Rasp Mine

Zinc–Lead–Silver Project

Response to Submissions Report

Project Application No. 07_0018

APPENDIX 4: PLAN OF FREE AREAS

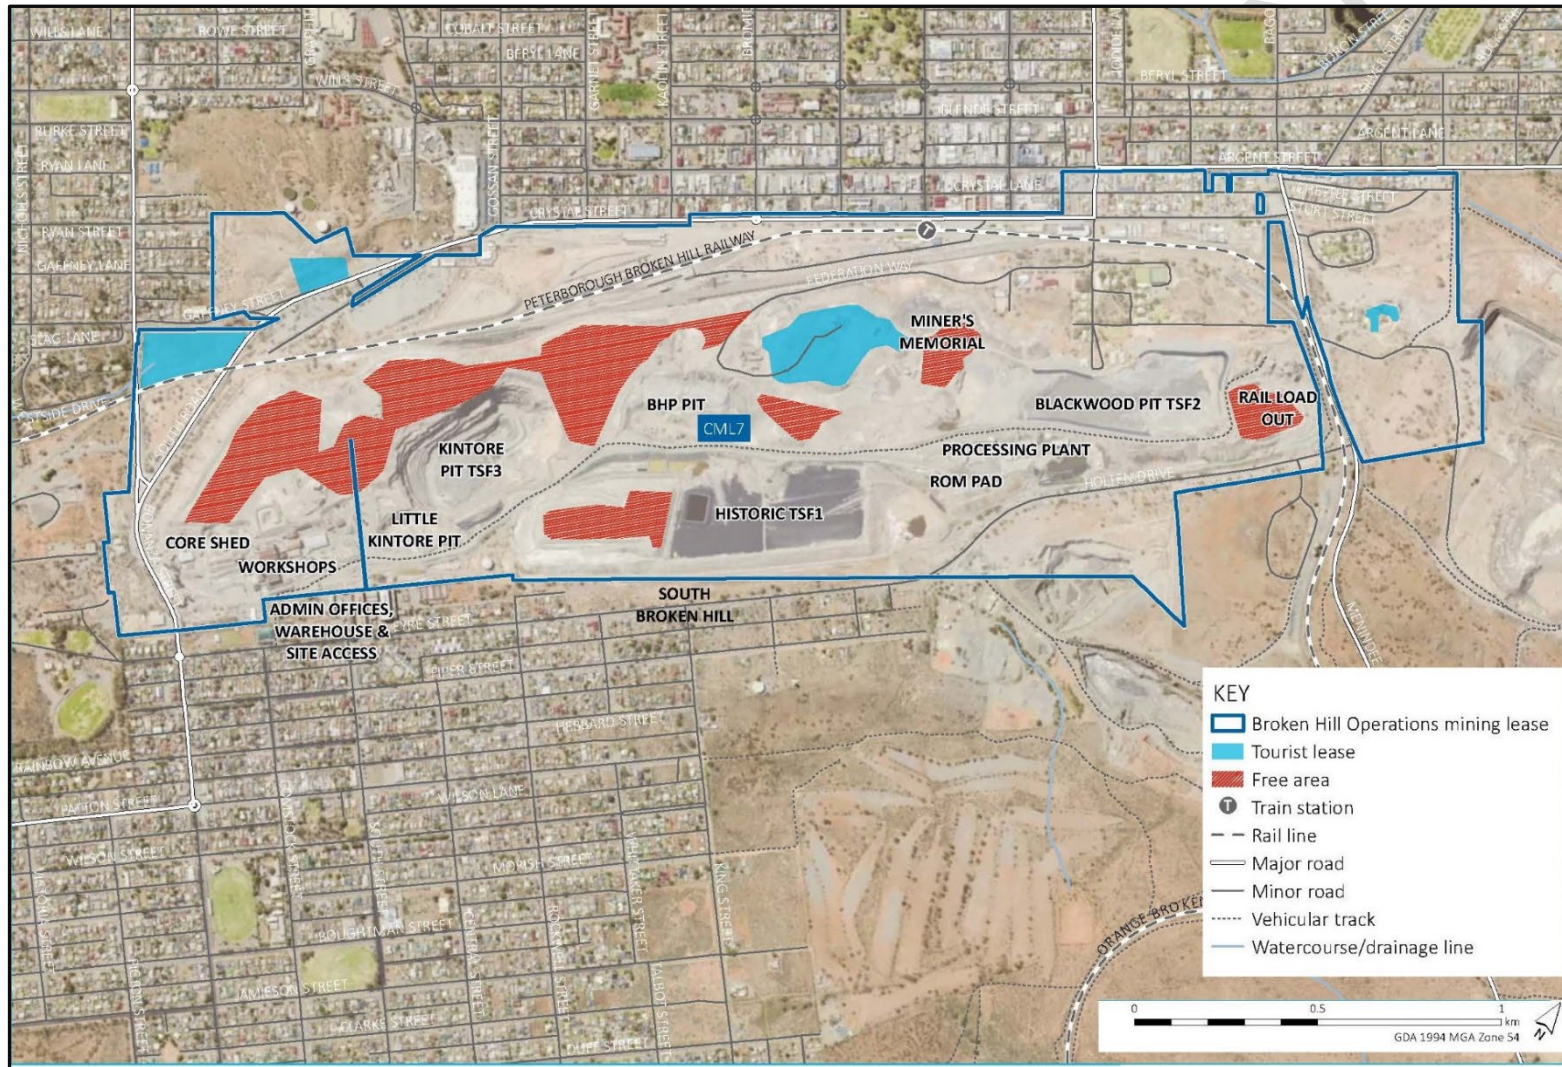
- **Provision of a map of mine “free areas”.**
- **Specify dust control measures for mine “free areas”.**

Chemical dust suppressants as per the manufacturer’s specifications, or more often as required, will be used on all areas of the site potentially impacted by wind erosion as per the ‘free areas’ marked on the following Figure.
